The Coal  
Authority

01 November 2021

**PLANNING APPLICATION: 2021/49/93689/E**

**Hybrid application for full planning permission for engineering works, drainage and utilities connection for the provision of site access from Forge Lane and Ravensthorpe Road and associated works; and for outline permission for erection of residential development and mixed use development (including community facilities) with associated works including the provision of internal estate roads and parking, landscape works (including provision of public open space, tree clearance/replacement/woodland management and ecological management) and sustainable urban drainage works drainage principles; Land To The South Of, Ravensthorpe Road / Lees Hall Road, Dewsbury**

LEGEND

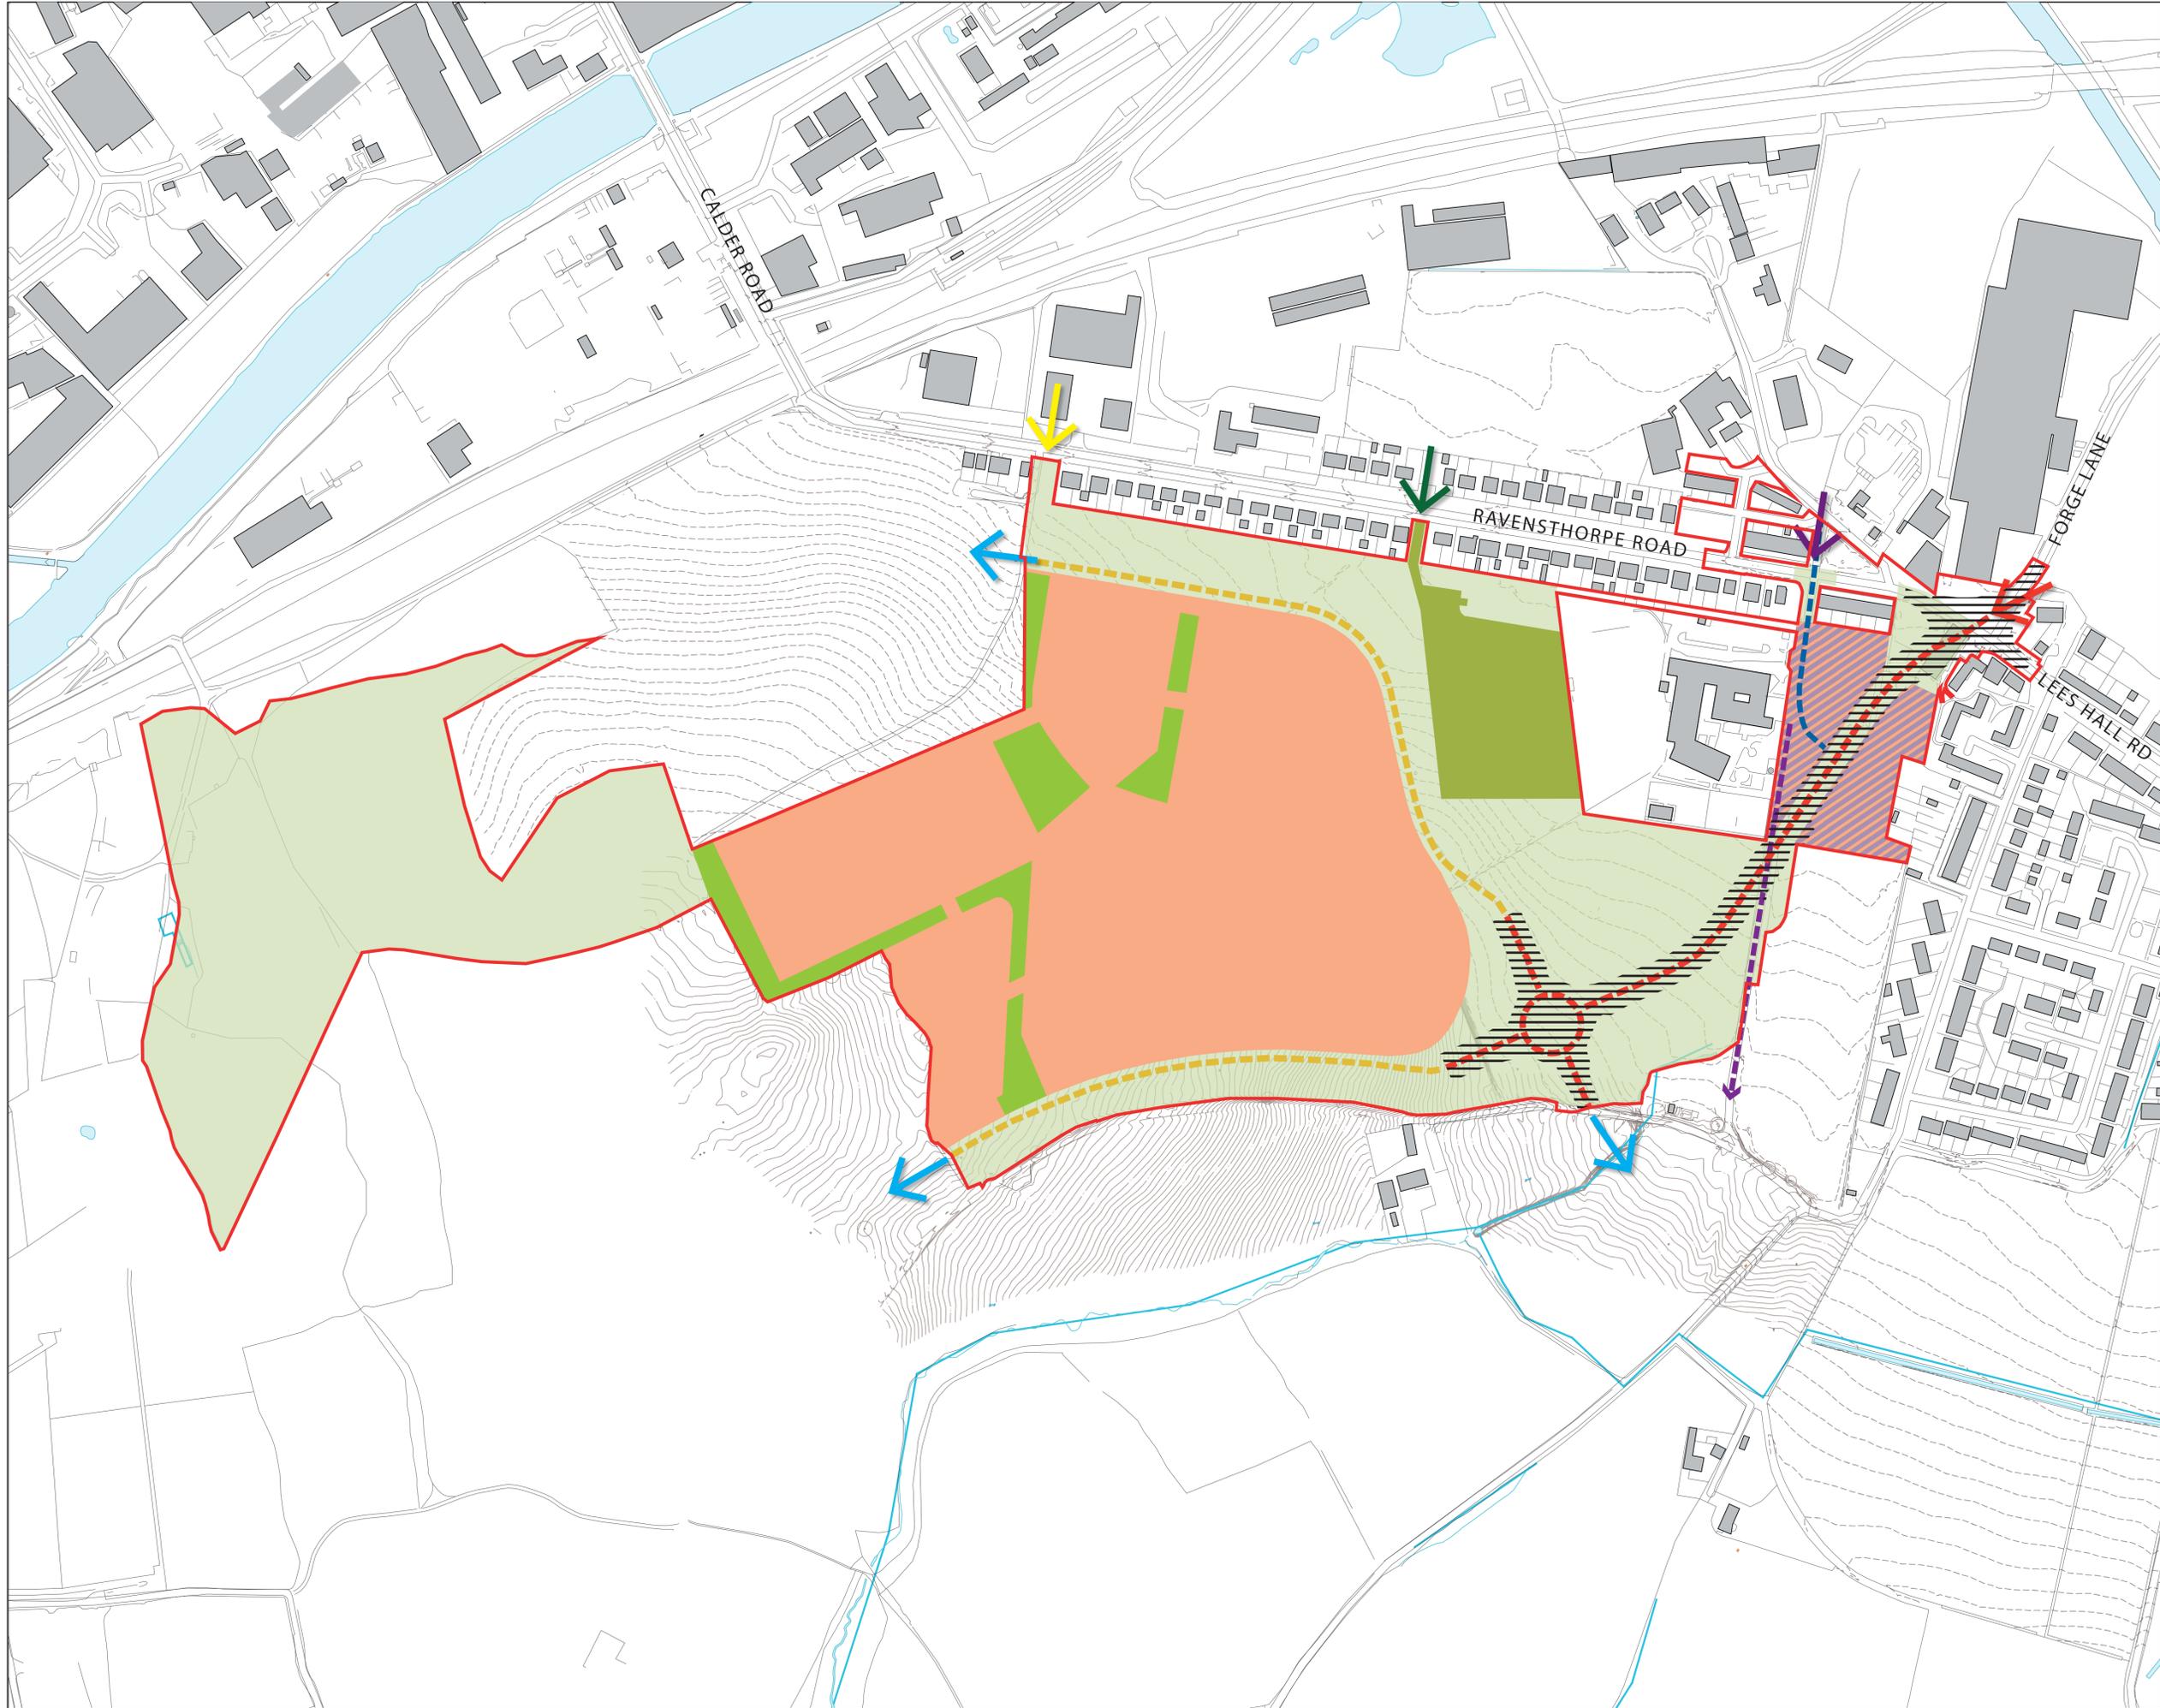
The report author identifies that there are 3no. recorded mine entries (CA shaft ref: 422419-027, 423419-004 & 423419-005) present within the area proposed for built development, with all remaining mine entries present within Lady Wood, beyond the areas of proposed development. However in accordance with the Illustrative Masterplan there is one mine entry (CA shaft ref: 422419-027) within the area proposed for development, and the 2no. mine entries (CA shaft ref: 423419-005 &

423419-006) are located within areas allocated as Allotments. We welcome the comments made that due to the history of mining at this site, there could also be unrecorded mine entries present at this site. Section 5.6.10 identifies that mine entries within the area of development will need to be treated / capped (in accordance with UK authoritative guidance: CIRIA C758D and under the terms and conditions of a Coal Authority permit (Permitting Process)).

It is noted that Section 6.6.3 of the Design and Access Statement informs that Lady Wood will be retained and enhanced, through a Woodland Management Plan. The majority of the c.33 mine entries are recorded in this area and as a result of proposed residential development adjacent to Lady Wood, will actively encourages members of public to use this woodland area,. **We consider that in order for the applicant to demonstrate to the LPA that there will be no risk to public safety as a result of enhancements to this area, further commentary from the applicant's geotechnical consultants is provided to the LPA on how they consider that the risk of untreated mine entries on public safety are to be addressed.**

3. As part of the reserved matters application, the findings of the intrusive ground investigations are provided to the LPA including the submission of the proposed layout plan which illustrates the location of all on-site mine entries found present within the site and their respective calculated no build exclusion zone.
